MECKLENBURG COUNTY  
Park and Recreation Department

MEMORANDUM

**RE:** Rezoning Petition #2022-048  
PID# 02911102

RZ-1

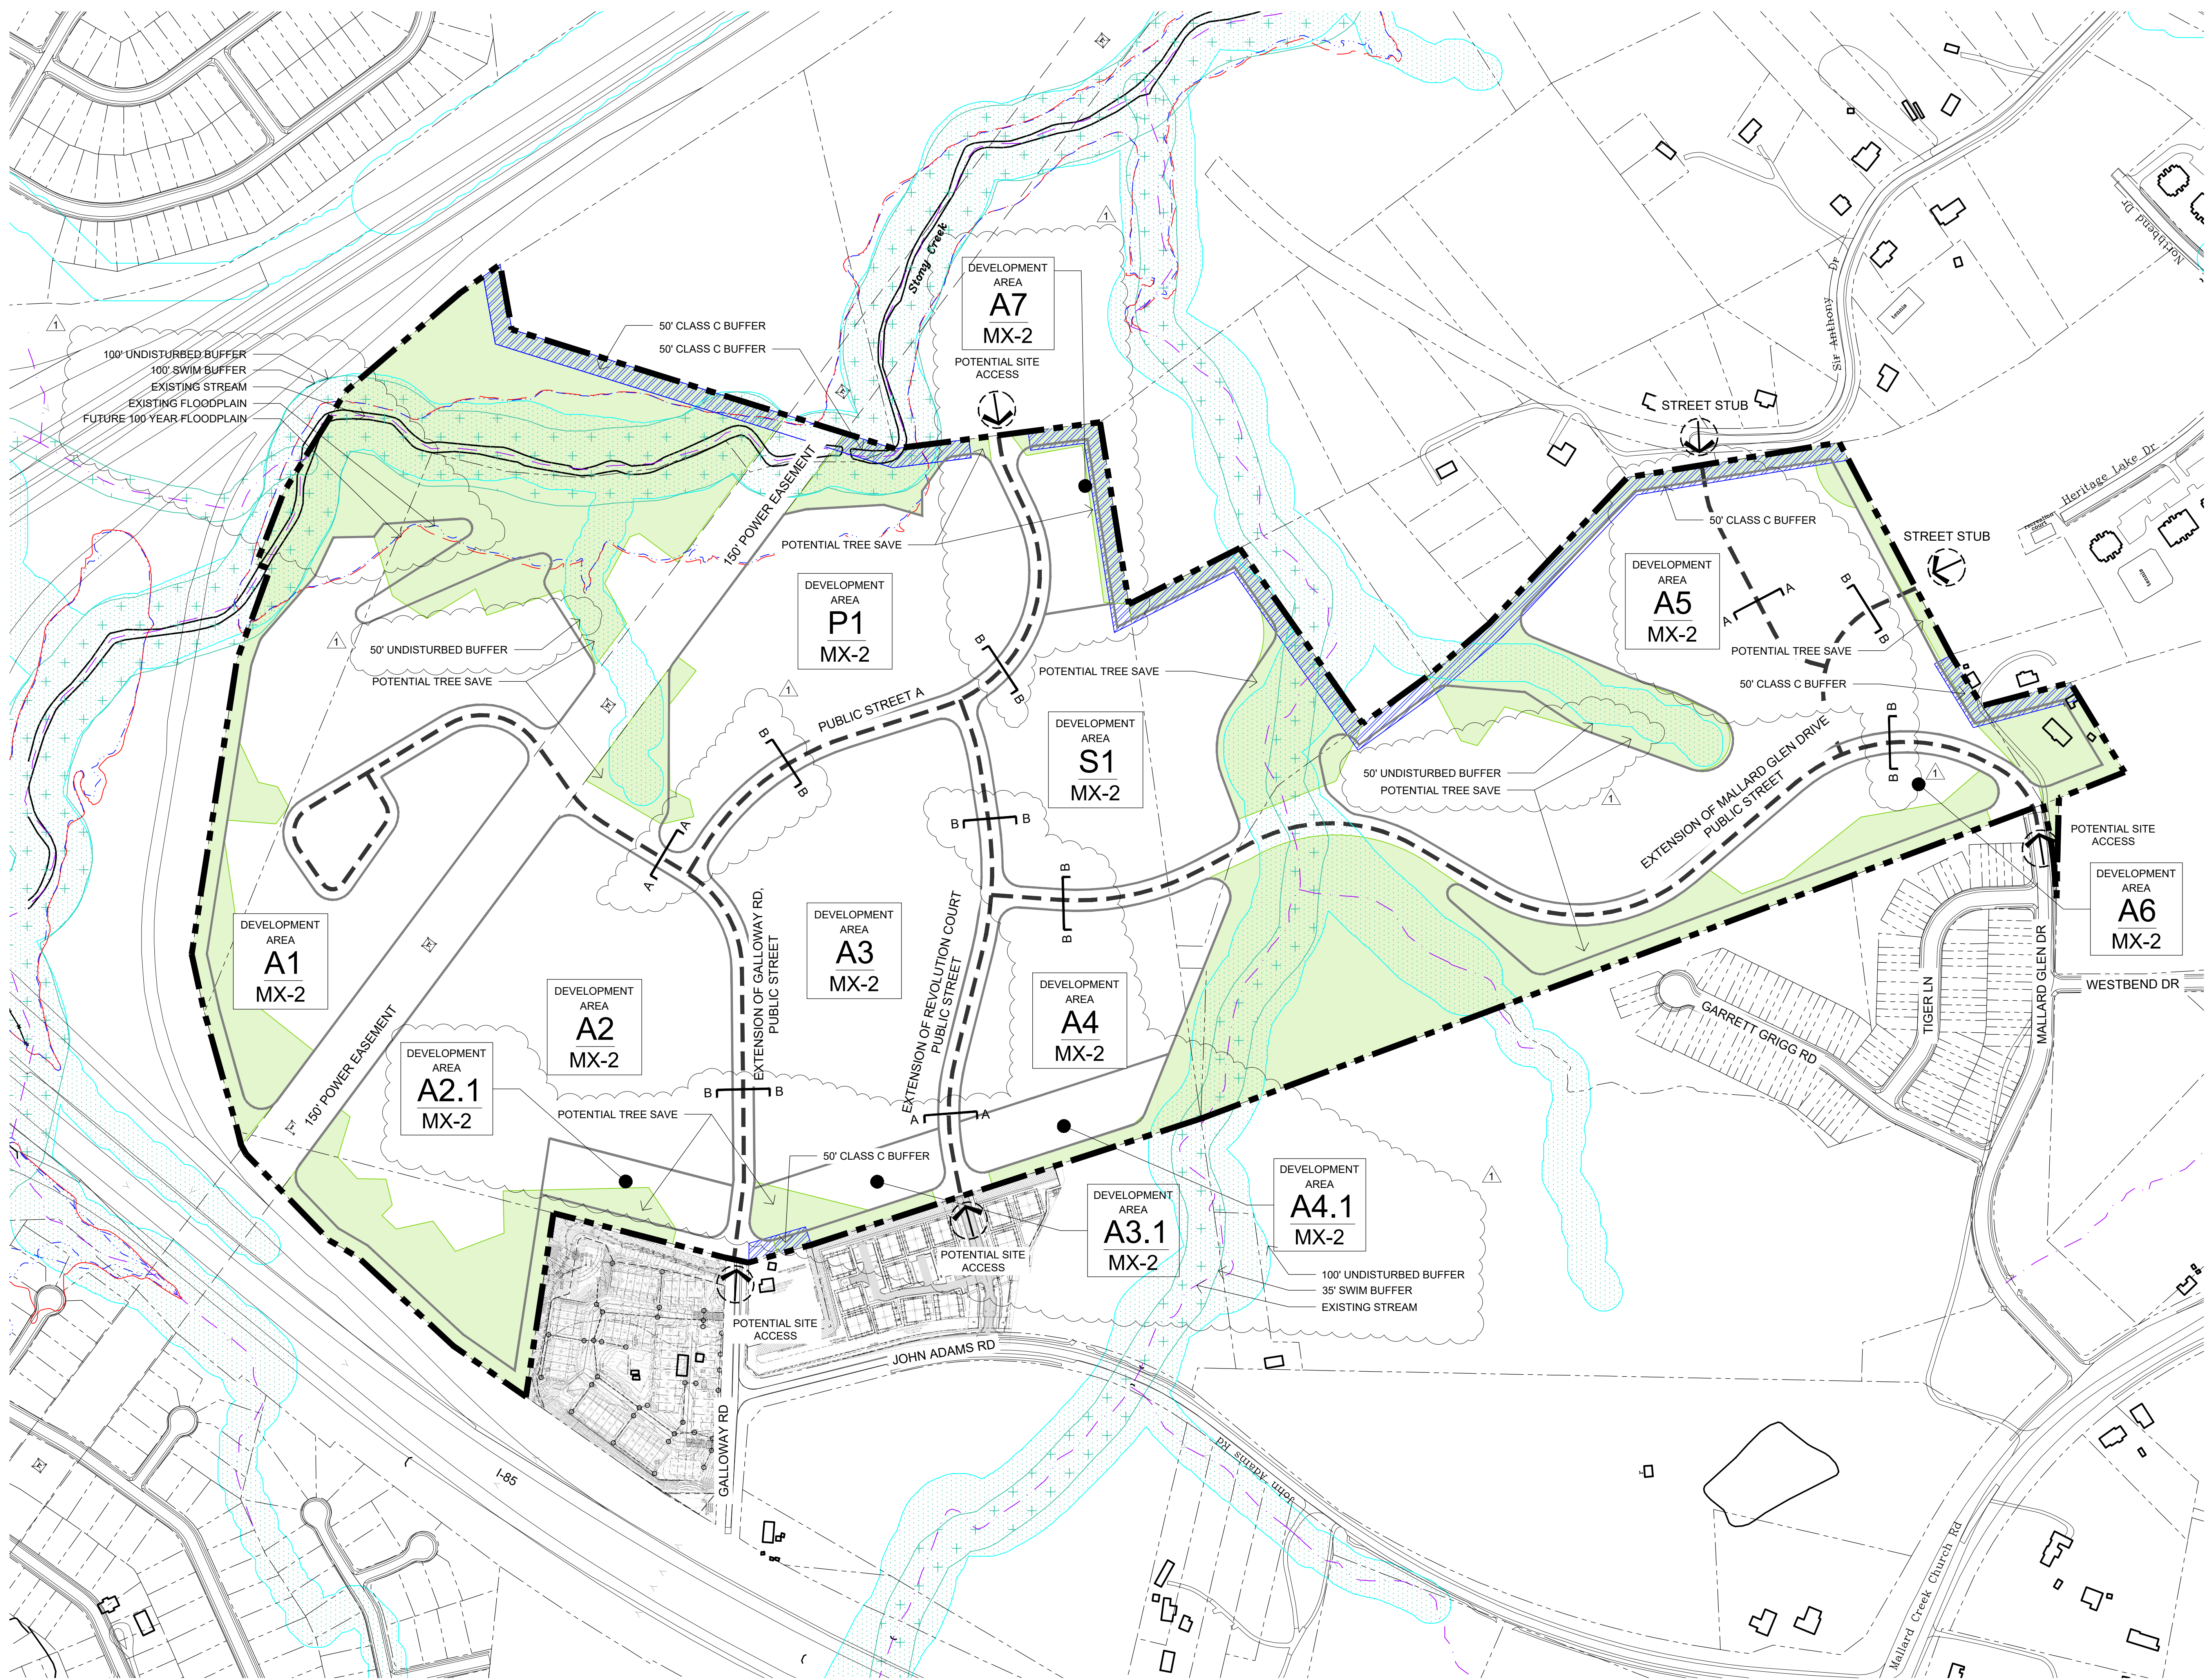
The plans show a 16 acre publicly accessible park. Please confirm if the park is intended to be dedicated and conveyed to Mecklenburg County. If not, MCPR requests a minimum of 9 acres to be dedicated and conveyed to Mecklenburg County for a future neighborhood park. This requested park land shall be adjacent to a public right-of-way for access and is conducive for the development of the typical amenities found in a neighborhood park and cannot include tree save parcels or stormwater BMP's.
